From: garry french [REDACTED]
Sent: 21 April 2021 21:39
To: Planning <Planning@arun.gov.uk>
Subject: Representation against FP/86/21/PL

Further to the submission of the new planning application submitted on behalf of Ms Bottomley, I am writing to express my representations against the proposed development; FP/86/21/PL.

PROPOSED SITE LAYOUT & MASSING

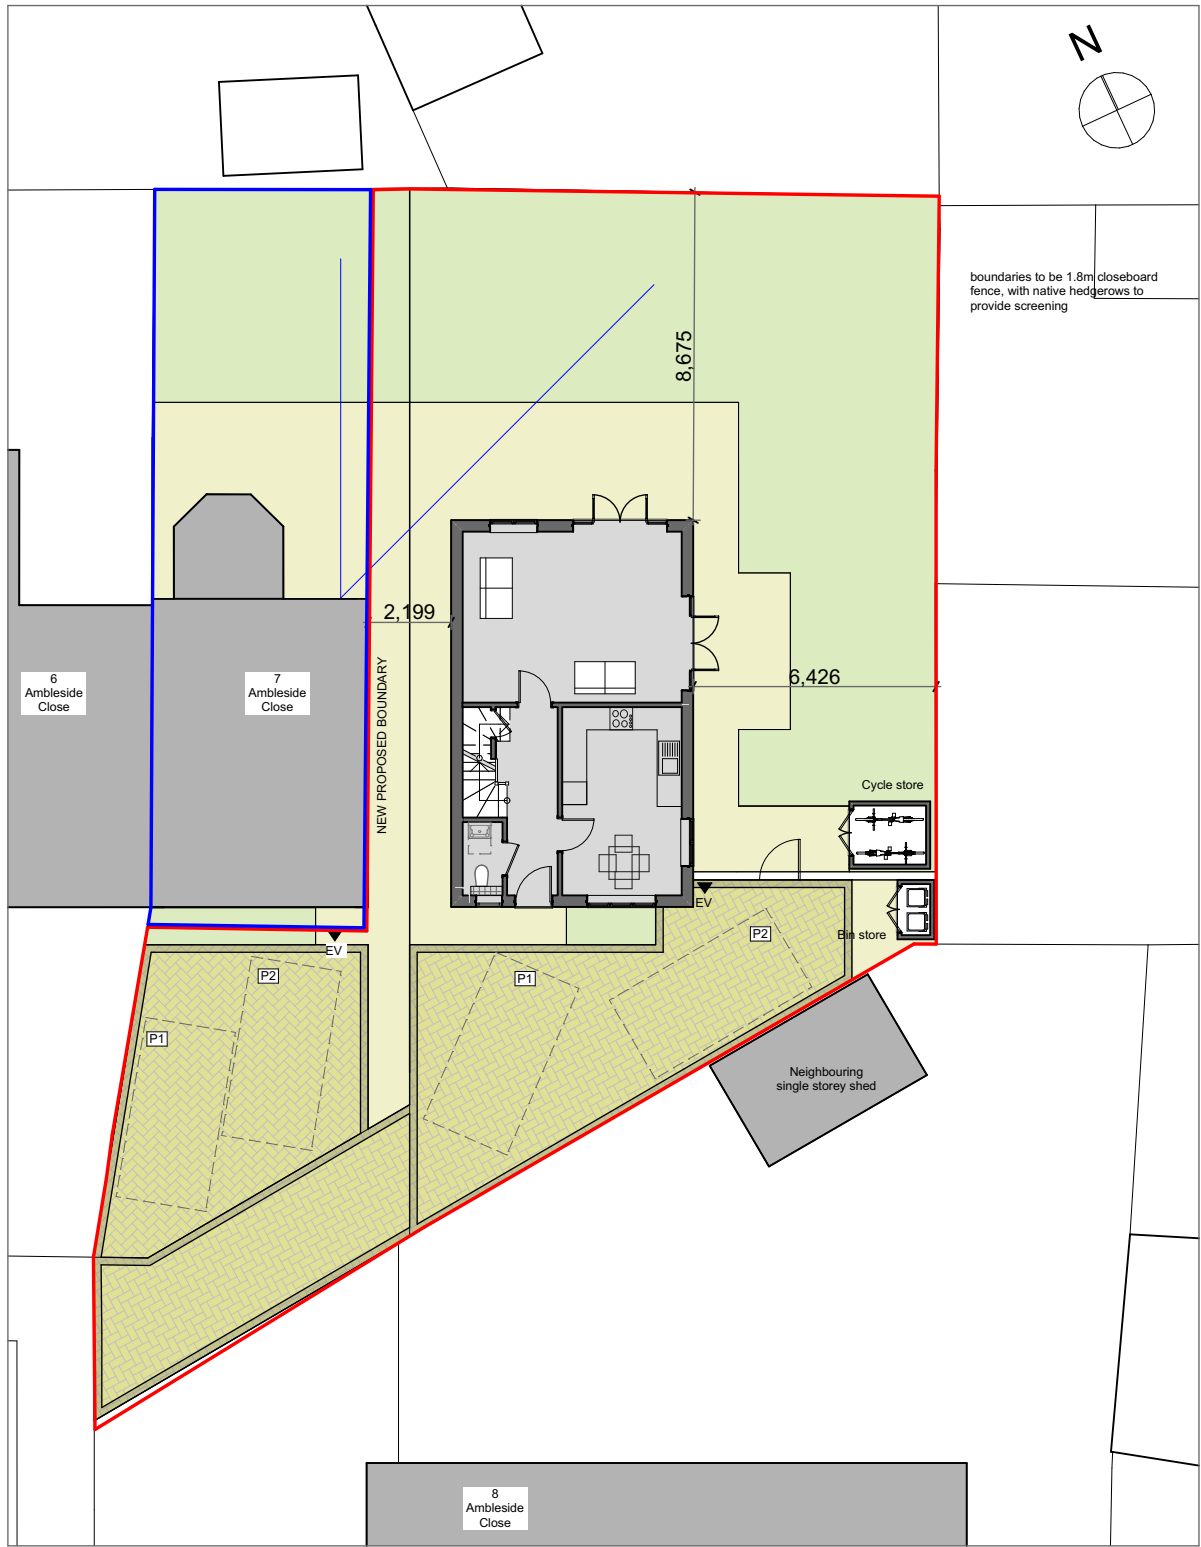
Further to the issue of parking, I notice that on the original planning application, West Sussex County Council raised concerns over the functional accessibility of the driveway, with concerns that it was just 2.8 meters wide, dropping to 2.4 metres, at the gateway. Despite this, the newly submitted plans do not make any attempt to address this. Furthermore, WSCC requested to see a demonstration via swept path that the awkwardly angled proposed parking spaces could be easily manoeuvred into and out of; again, a concern I see the applicant has failed to address. The cul-de-sac has been subject to disputes over parking problems for a number of years and these can only be exasperated by an additional dwelling - especially if the parking spaces prove to be too irregularly angled for frequent and accessible usage. The width of the driveway also begs the question how goods vehicles will get materials onto and off of the site, without damaging my property.

The plans suggest that a shared brick pier will be removed, but as of yet, I have not been approached regarding this coming down, and I will not be giving consent for this to happen by means of a party wall agreement.

PROPOSED FLOOR PLANS

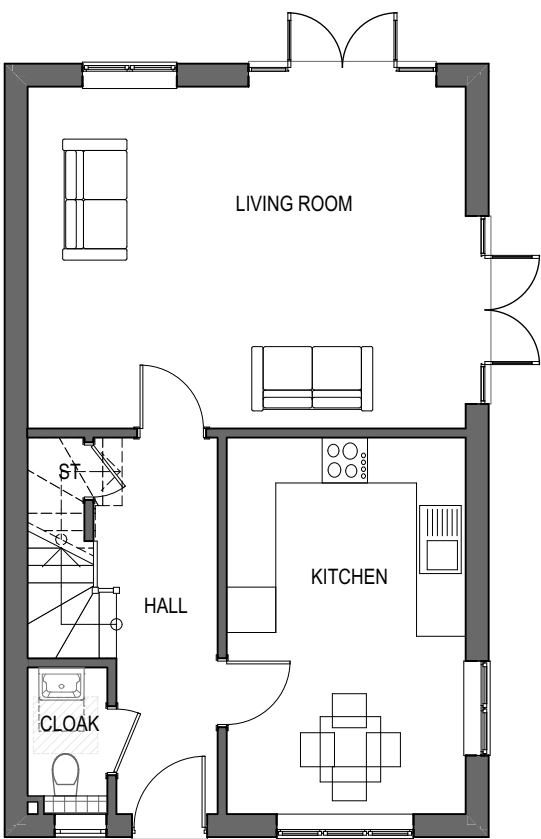
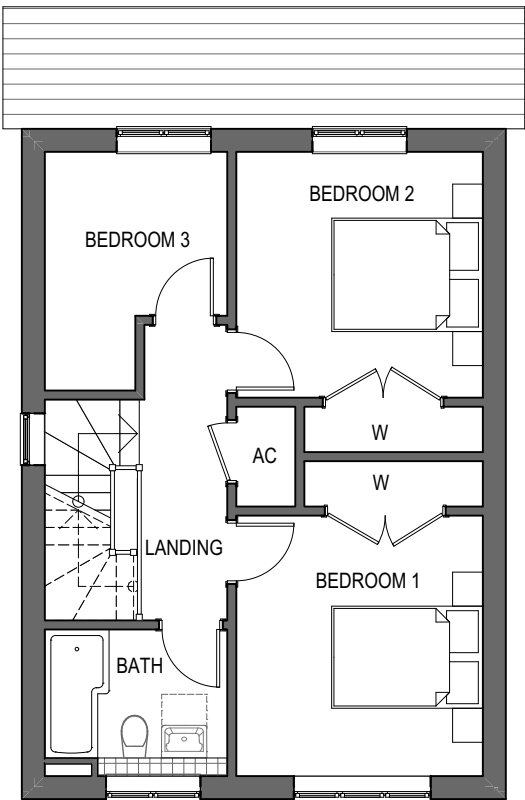
Having reviewed the proposal; I am at once struck by how there would only be a distance of approximately 2.199 metres between the landing window and that of the existing property and that proposed. Furthermore, the design would have bedroom windows located approximately just 14.7 metres between the landing of my own property and that proposed, and the property's window line would run parallel to that of my heavily glazed kitchen; providing an unobstructed view into the living areas of both properties, making the living conditions of both parties most uncomfortable.

PROPOSED ELEVATIONS

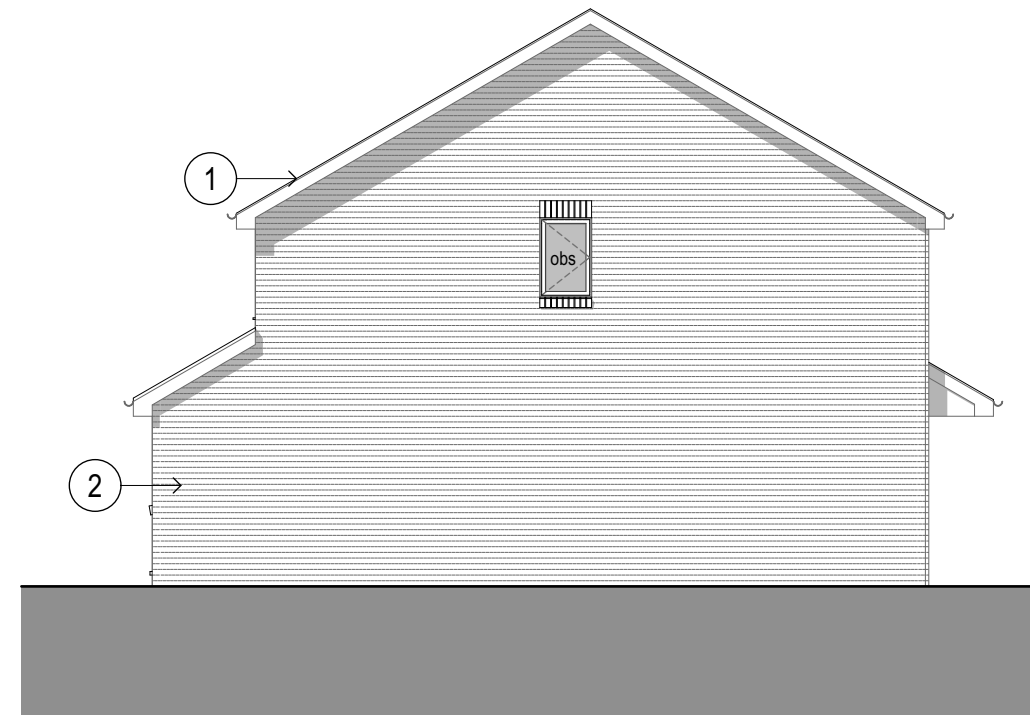
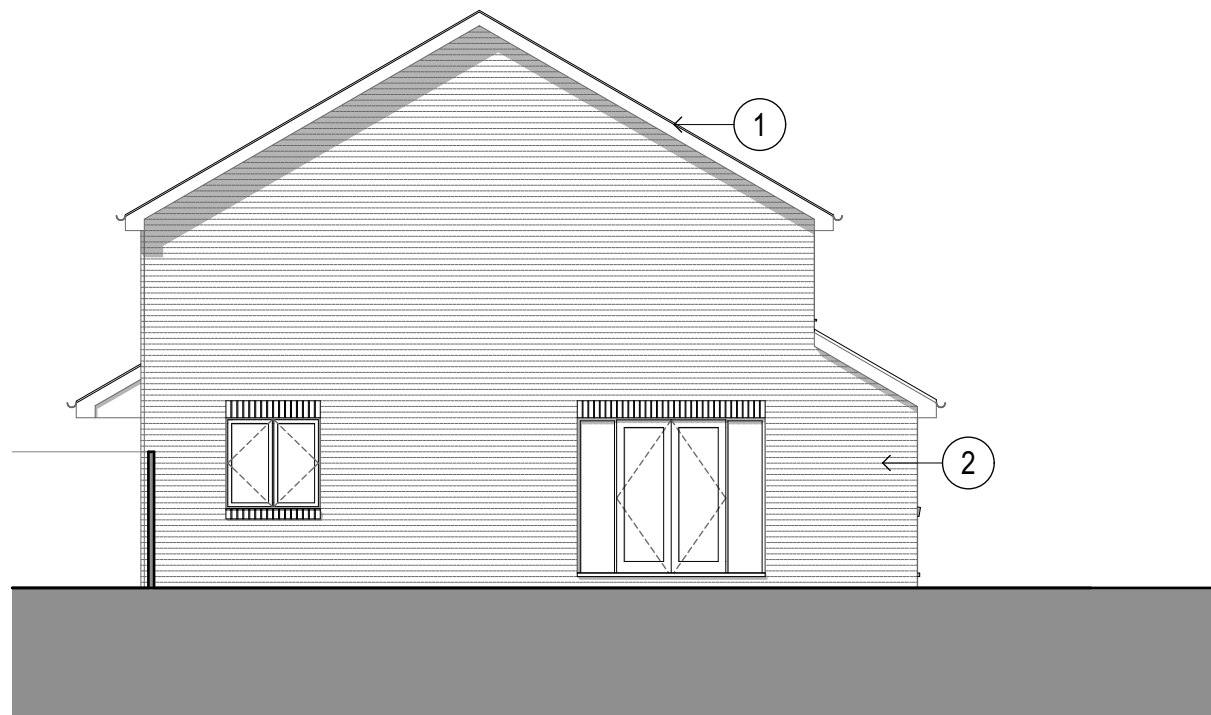
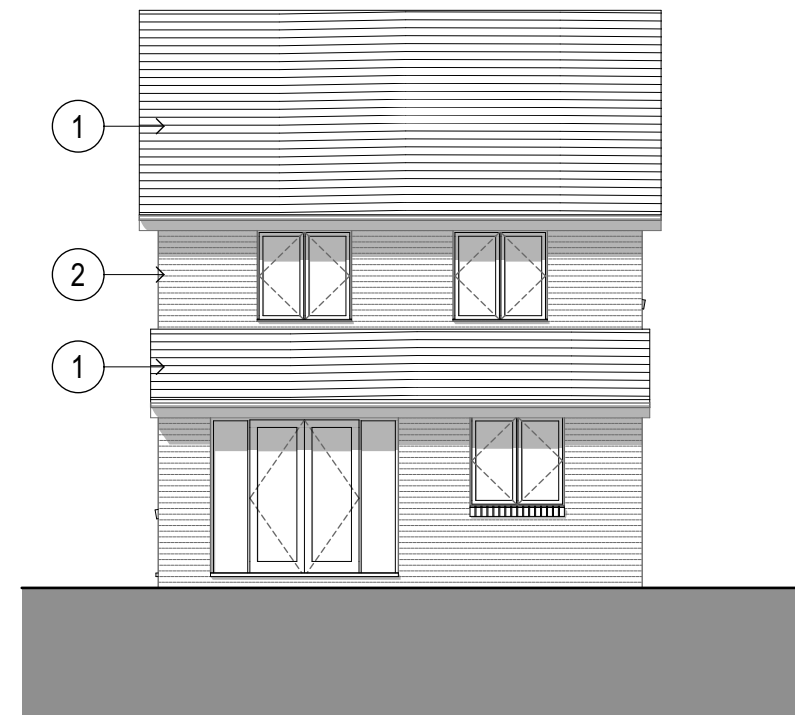
Although more to the scale of the surrounding properties, the proposed development has been designed in a way that causes it to fail to match the street scene; grey windows, grey roofing, buff grey brickwork and weatherboarding are all a departure from the other properties in the vicinity and at once the design appears at odds with the established surroundings. The building is also 15 centimetres taller than that it will be constructed in the garden of, with the reason for this given as "to allow sufficient headroom" but I fail to understand how this is required - is the headroom of the existing property not sufficient enough?
